Our Ref: EN010137

Date: 8 November 2024

### **Procedural Decision following request to make changes to the application**

Change 1a – Order Limits change to include an existing access track to the west of the onshore substation for temporary access during onshore site preparation works

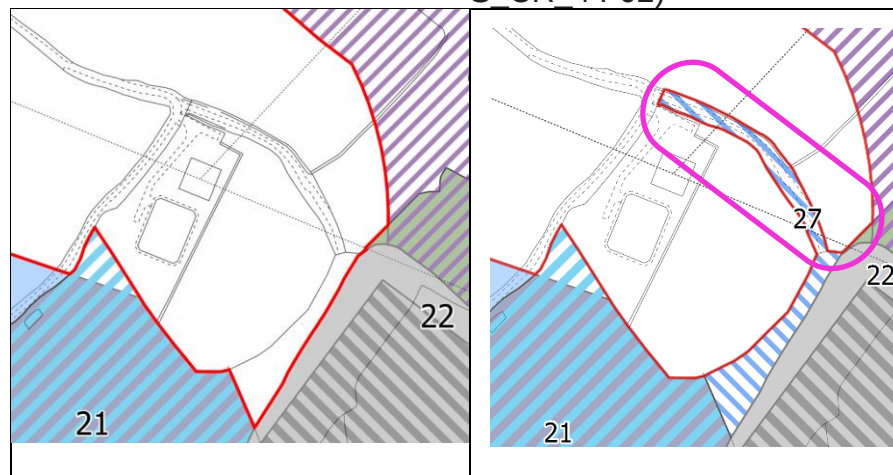
However, the CRR is not clear and is somewhat contradictory on the reason for the inclusion of this land and its intended use. Therefore, the ExA is unable to provide further advice on Change 1 until the Applicant has provided more clarity on the matters below:

- Could the Applicant explain why the proposed change is necessary if being utilised for onshore preparation works only?

- Paragraph 1.2.13 of the CRR states that it would be used to take access for Work Nos. 21, 22, 23 and 31. However, Paragraph 1.2.1.6 states that it would be used for temporary access to Work Nos. 21-24, 27, 29, 32, 33 and 26. Can the Applicant clarify which Work Nos it is seeking access for?

- The CRR states that the access would be used for onshore preparation works only such as time critical surveys. Paragraph 1.2.1.8 then states that use of this access would reduce the need for contractors to track equipment around the onshore substation from the temporary construction compound and laydown areas (Work Nos. 23, 24 and 25) to implement the necessary works around the west and south of the onshore substation platform. Can the Applicant confirm what is meant by paragraph 1.2.1.8?

- Is proposed Change 1 solely for onshore preparation works and can the Applicant confirm that it would not be used during construction? How would the Applicant propose securing this in the DCO?

- Section 2.9 states that this would only be used for 12 months and only by 4x4 vehicles and that daily movements would be de minimis. How would the Applicant propose securing this in the DCO?

- Does the Applicant propose on submitting the assessment of access and road safety it states that it has carried out?
